PLANNING AMENDMENT

H08/0089/01

Plot 1, Apple Crumble Court, off Belchmire Lane, GOSBERTON

Amendments to Living Room size
and Bedroom over (Reduction)

First Floor

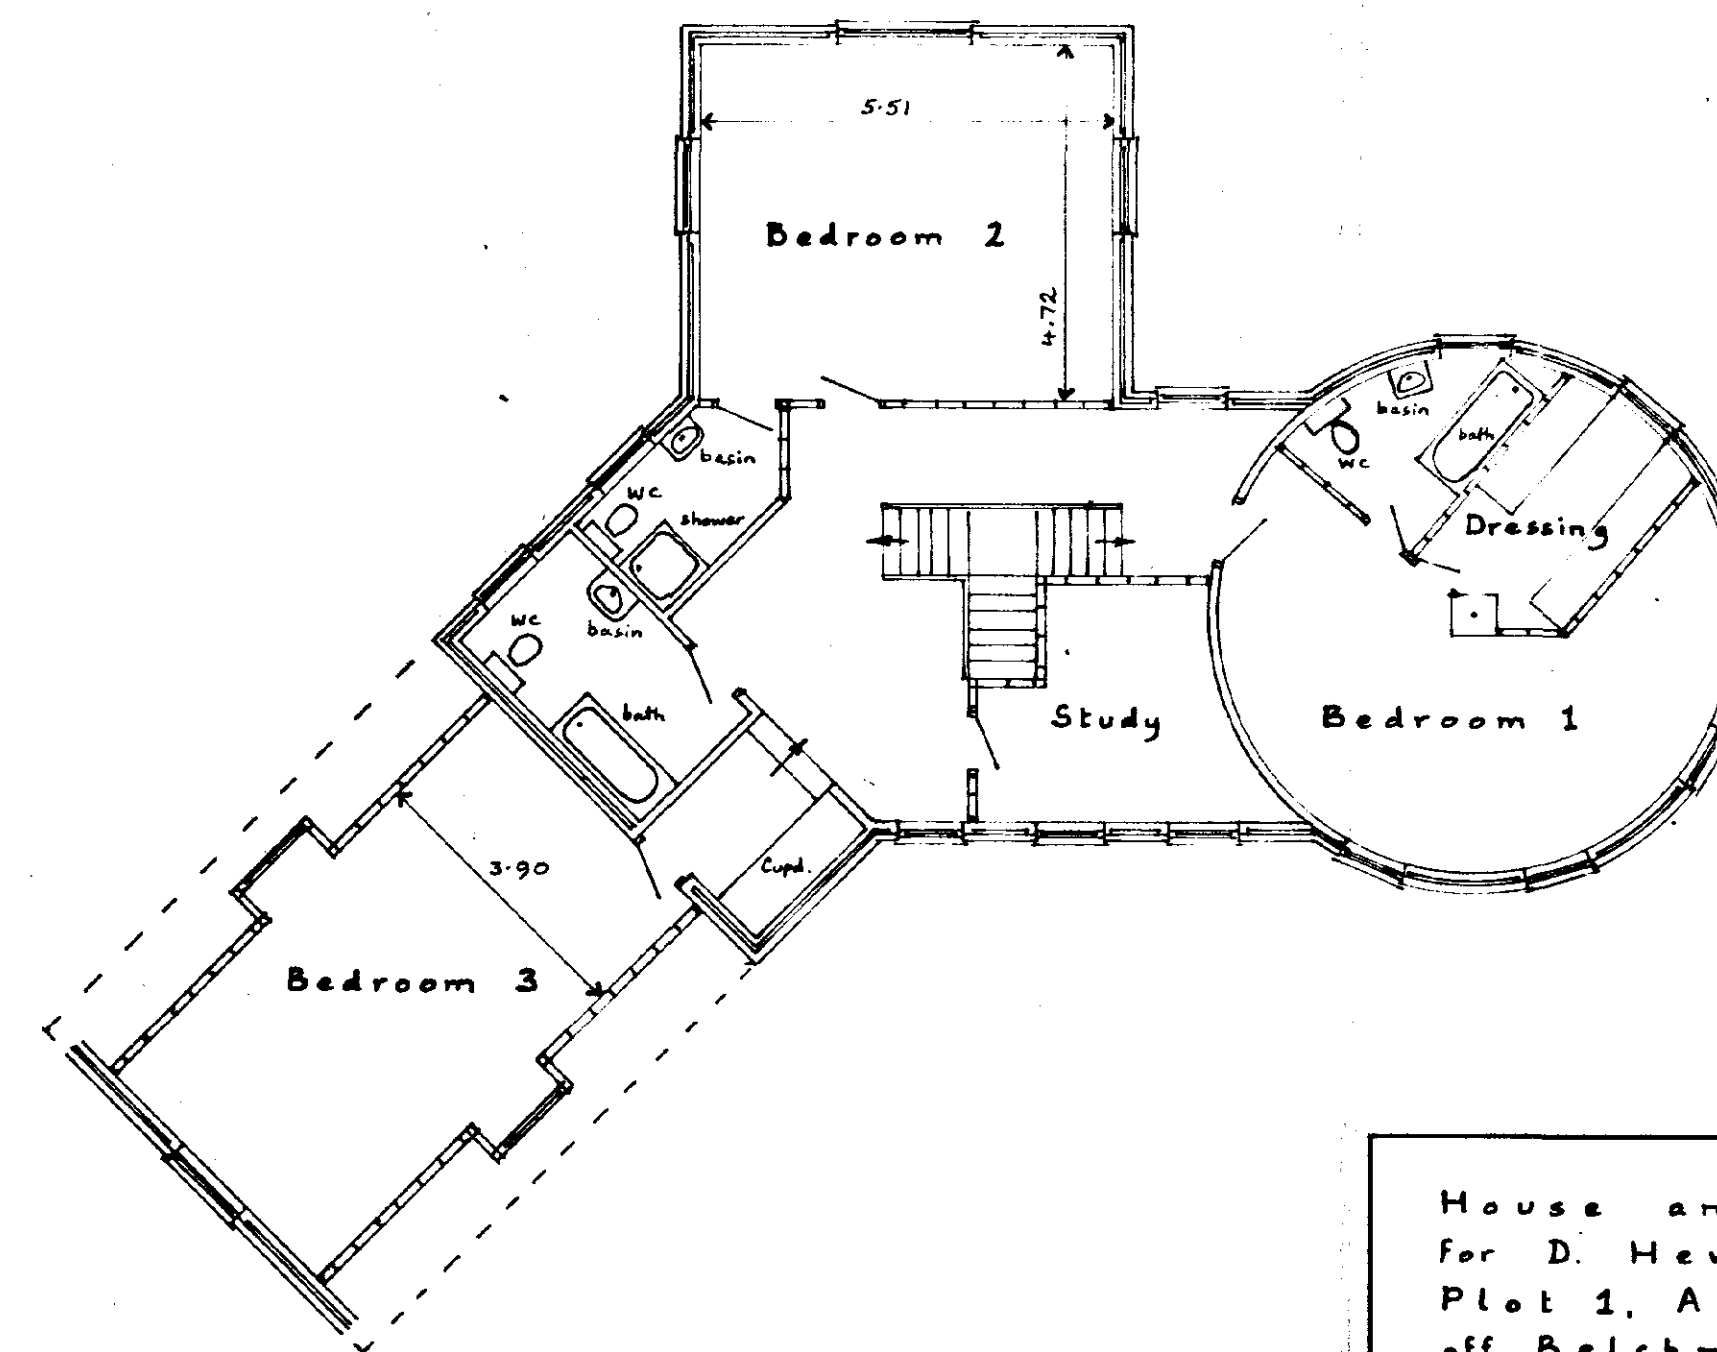
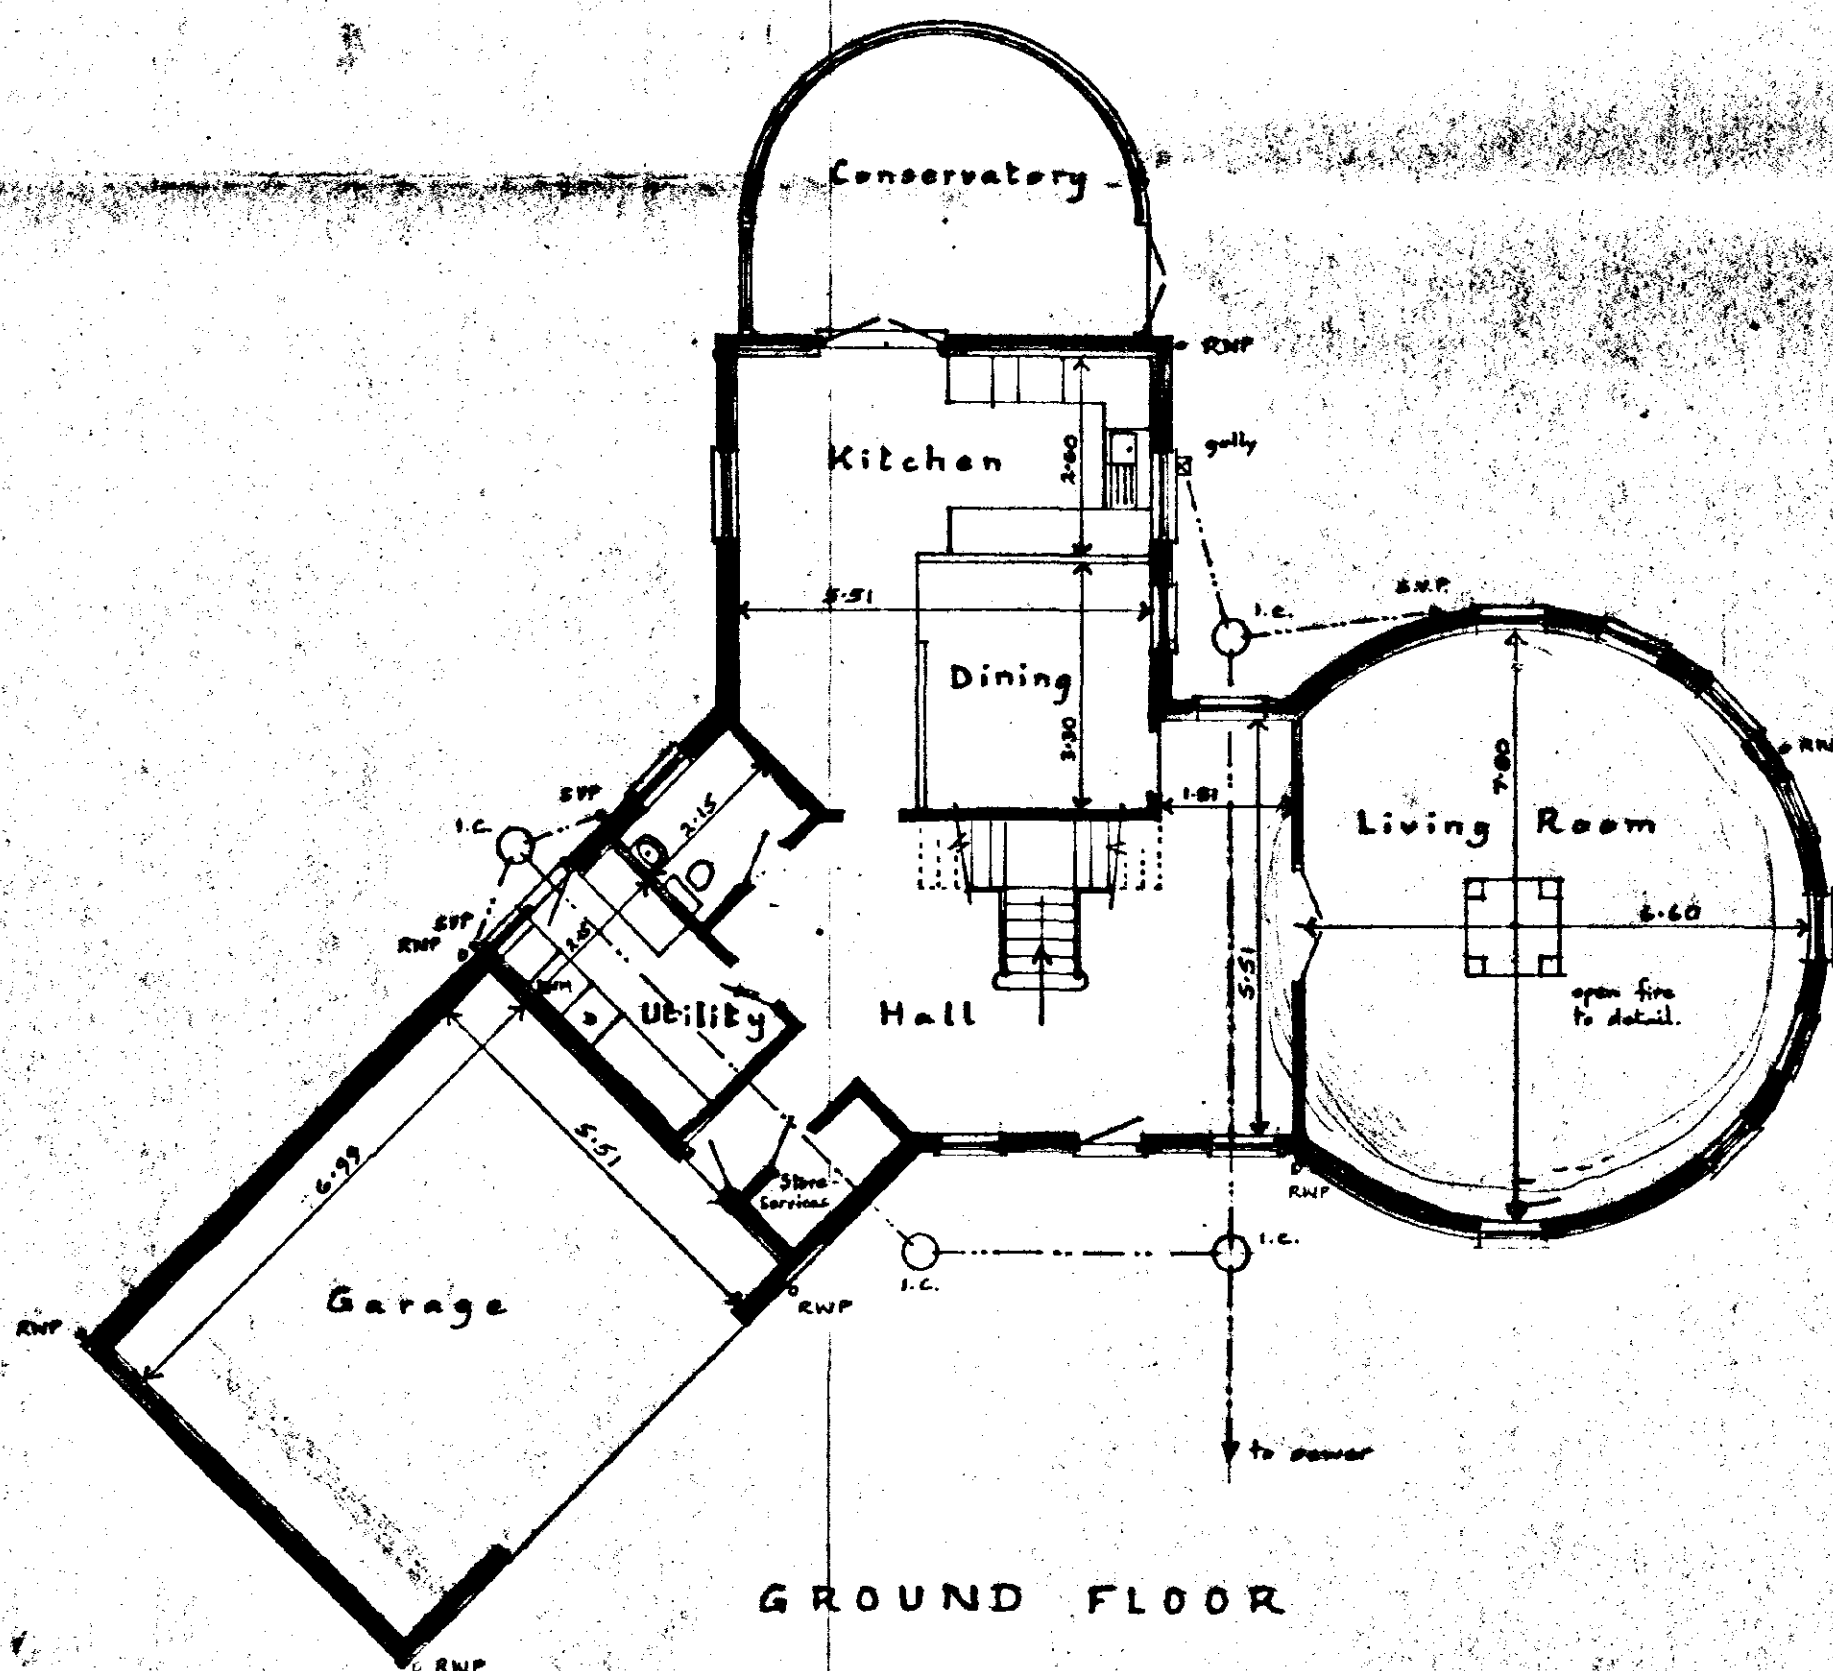
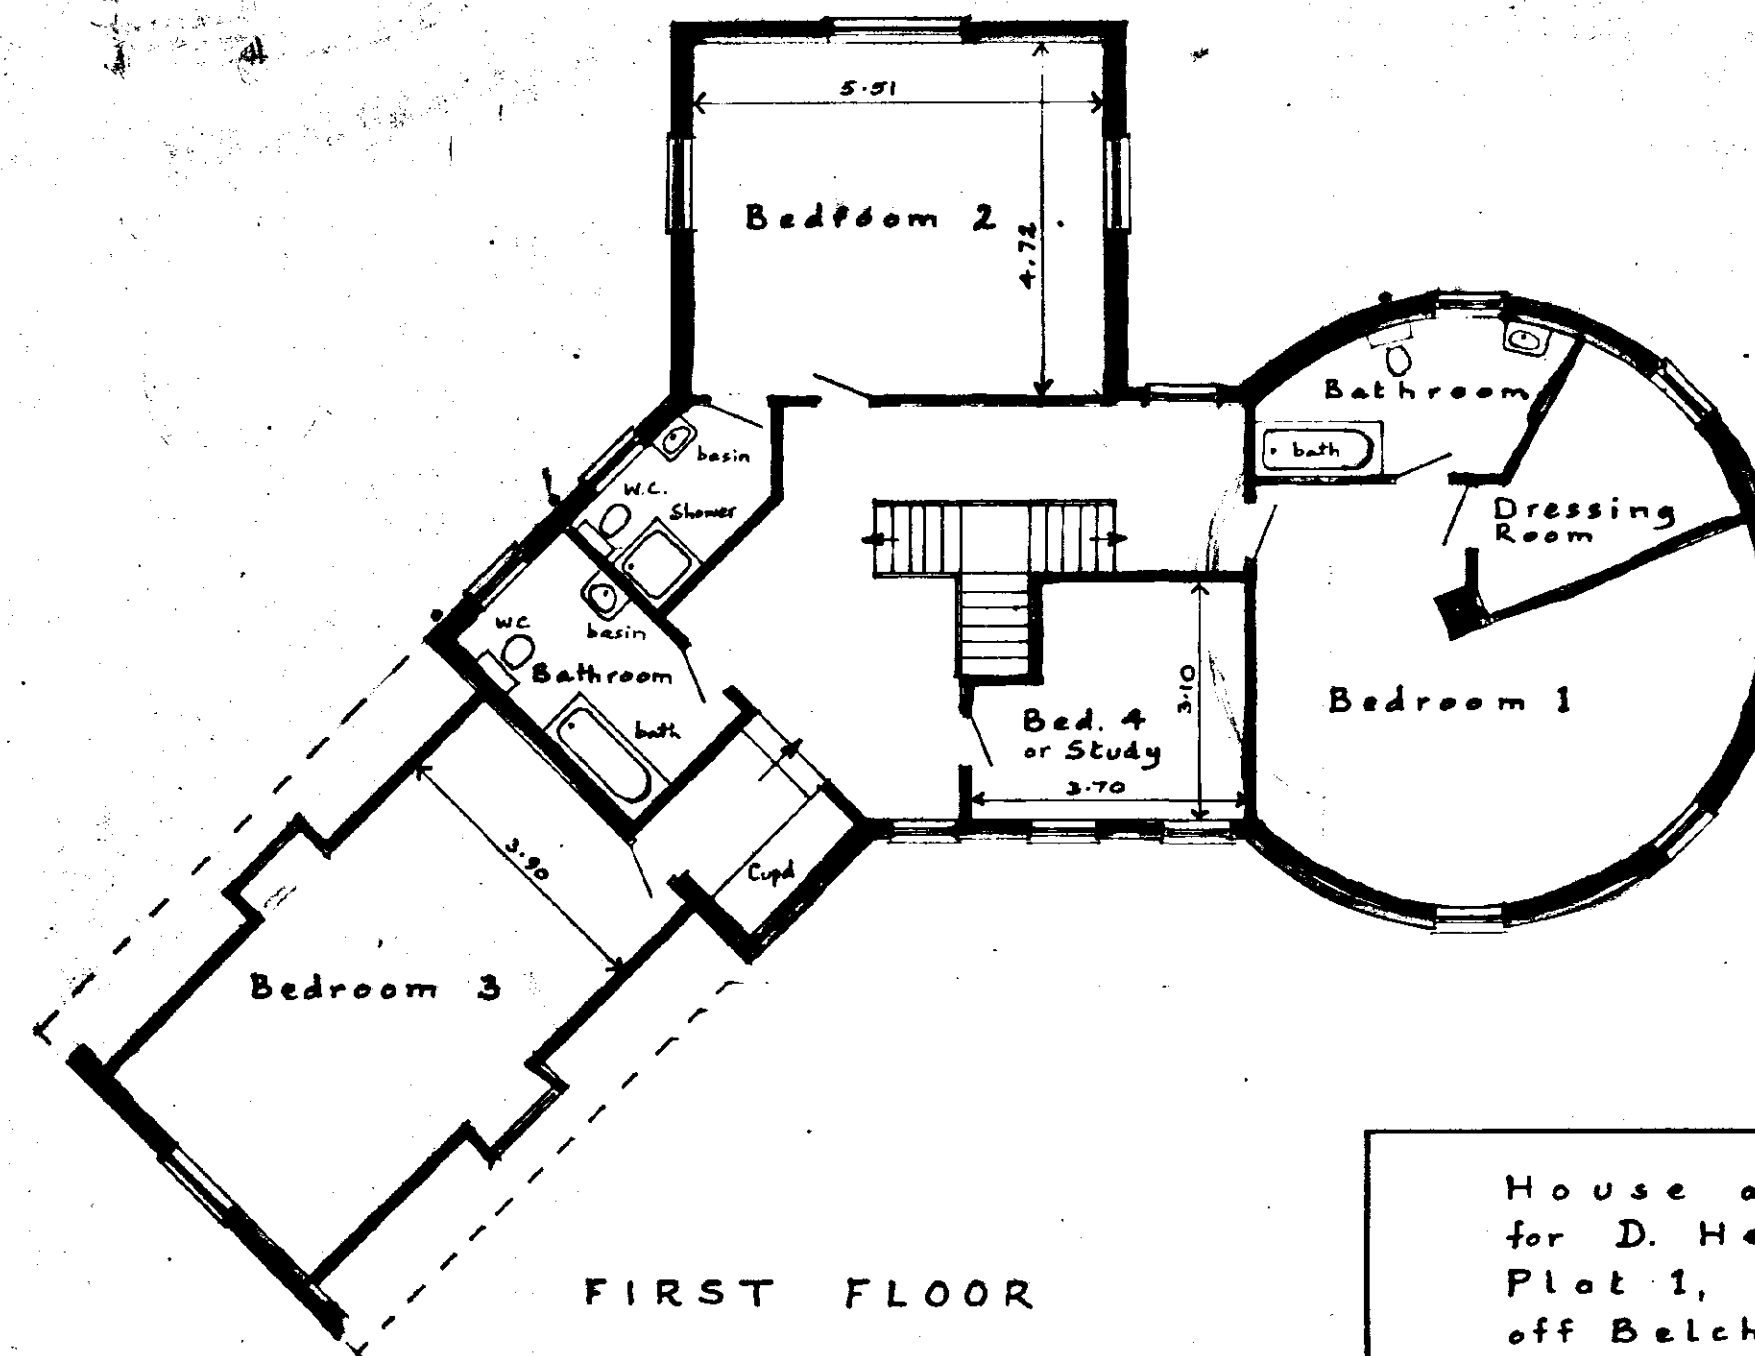
Amendment: Amendments to living room size and bedroom over
(Dwg nos. 210418 & 201113A)
